Subject: FW: Application number : A/8/18/PL

Subject: Application number : A/8/18/PL

Jane Runacres
4 The Cottrells

Block Plan

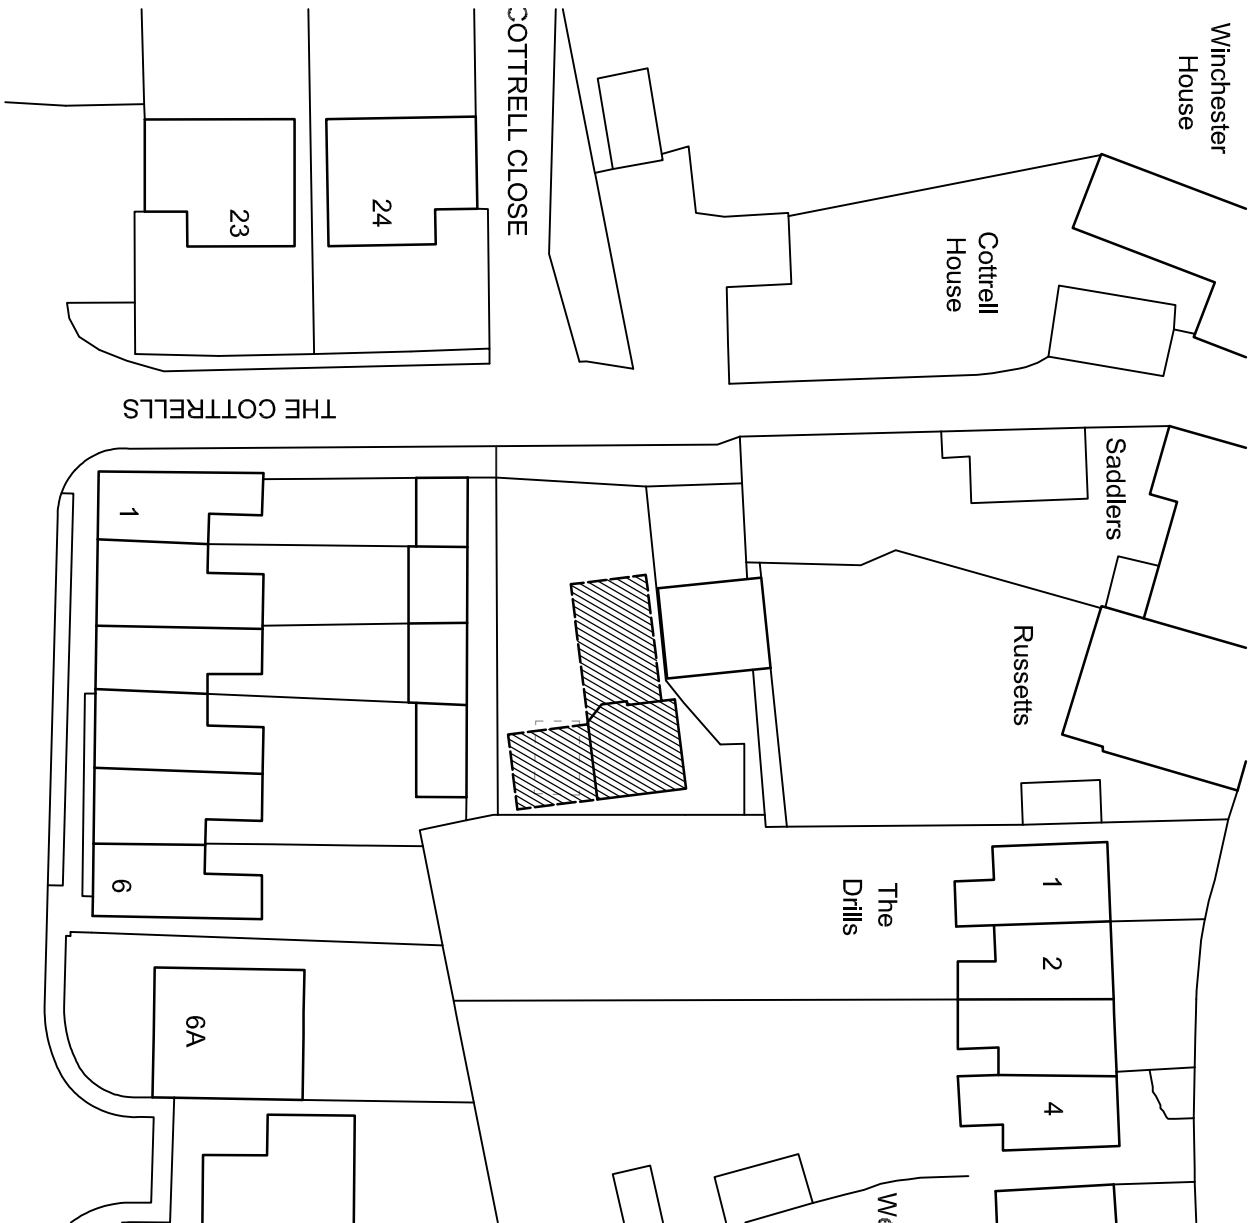
- 2.South boundary - the wall and kerbstone marking the boundary between the development and the shared alleyway have encroached on the alleyway. The wall appears longer than on the plans, encroaches on a drain cover and the kerb is built on the alleyway and not on the land belonging to the development.

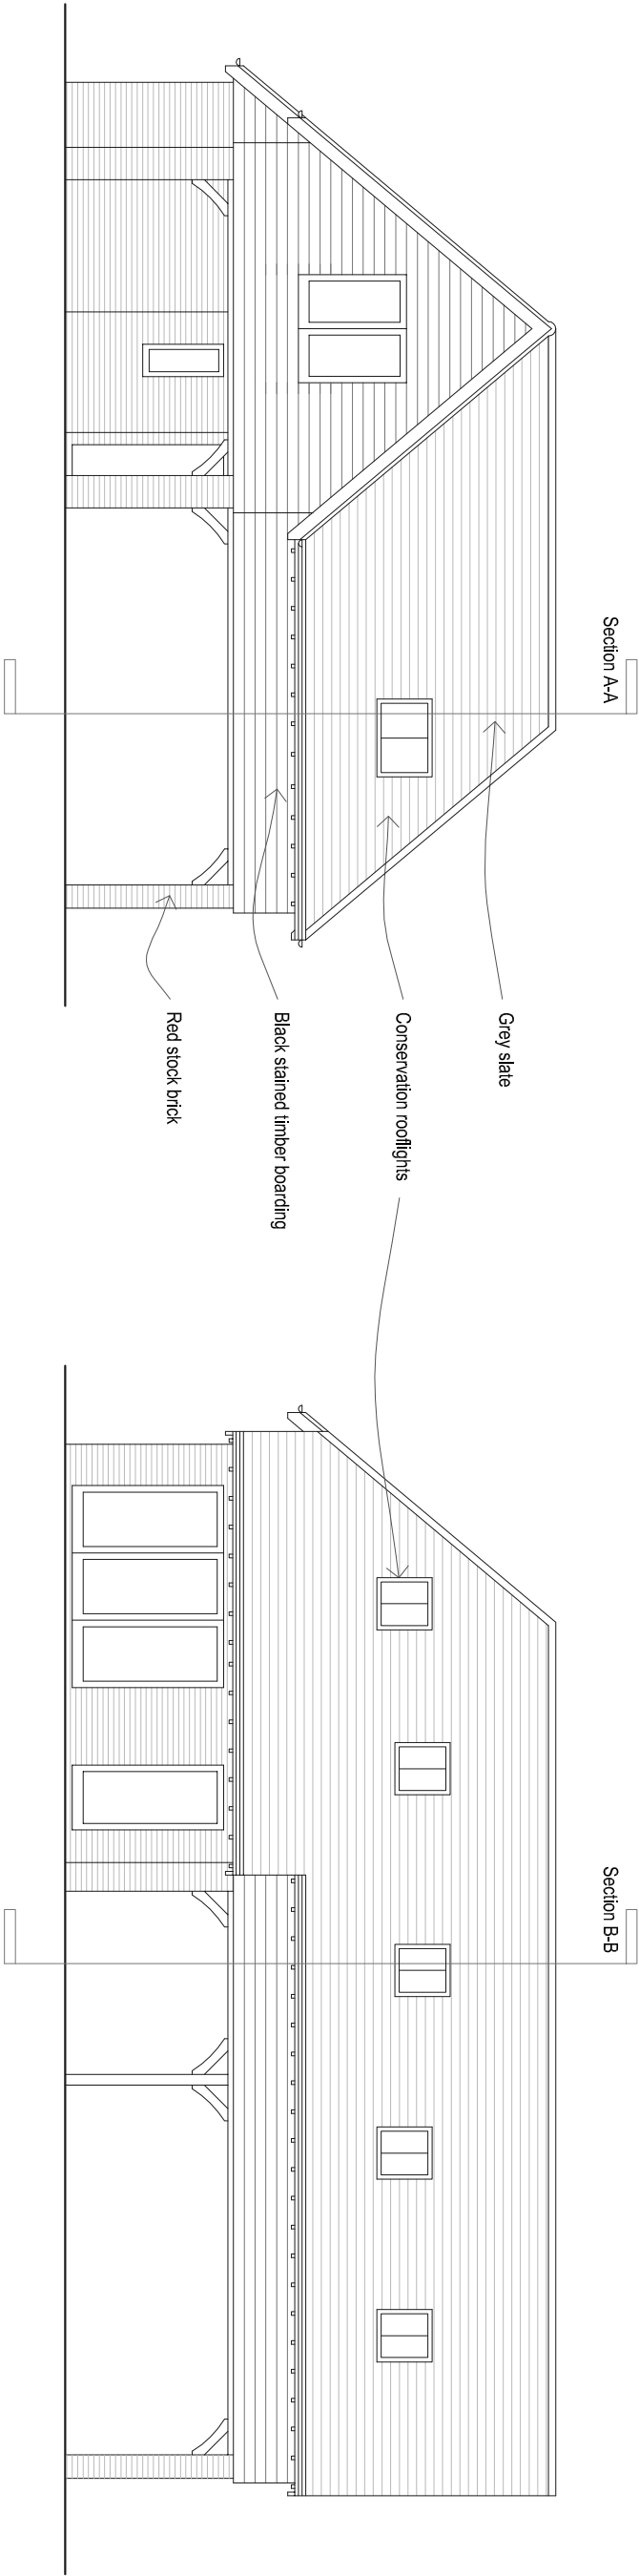
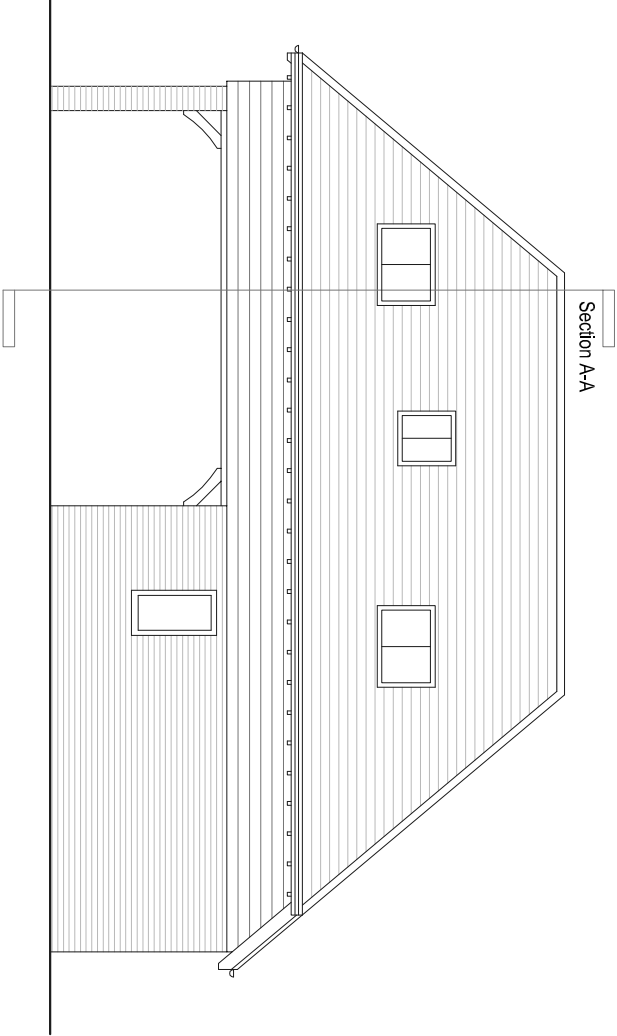
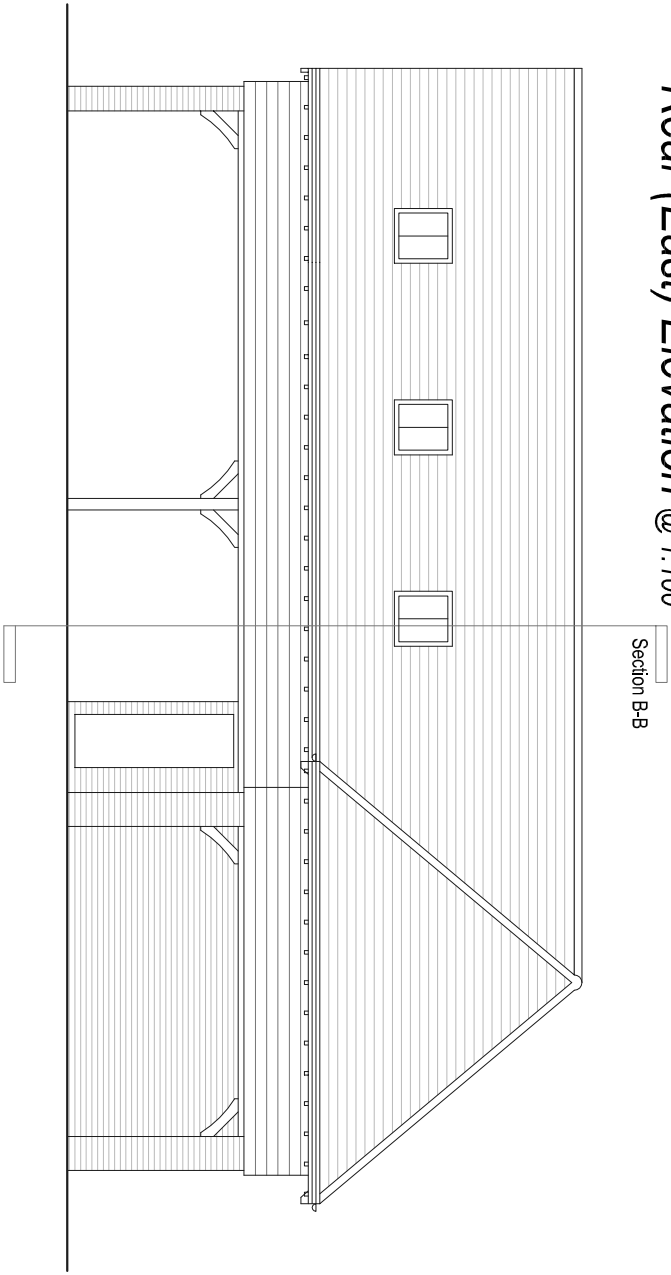
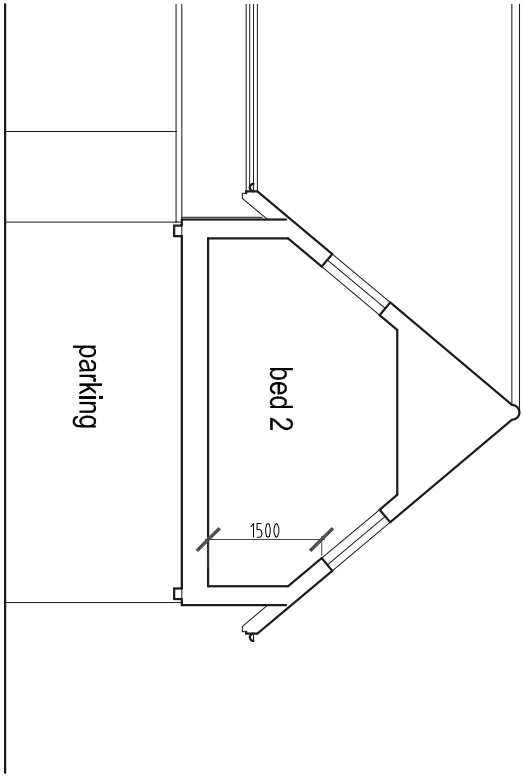
- 1.Windows - the height and position of the windows allows people in the new building to view directly into our bedrooms, bathrooms and gardens. This direct view is of considerable concern as an invasion of privacy and even more so as the bedroom at the rear of the property is frequently that of the children of the house. The windows concerned of the new property are of the main living area and will be in frequent use, and as children's bedrooms and out bathrooms are also used heavily. As the new property is higher than ours the occupants are looking down on us and therefore have a clearer view. We asked if frosted or obscure glass might be a possible compromise. We also raised that the windows and roof ridge are not conservation standard.
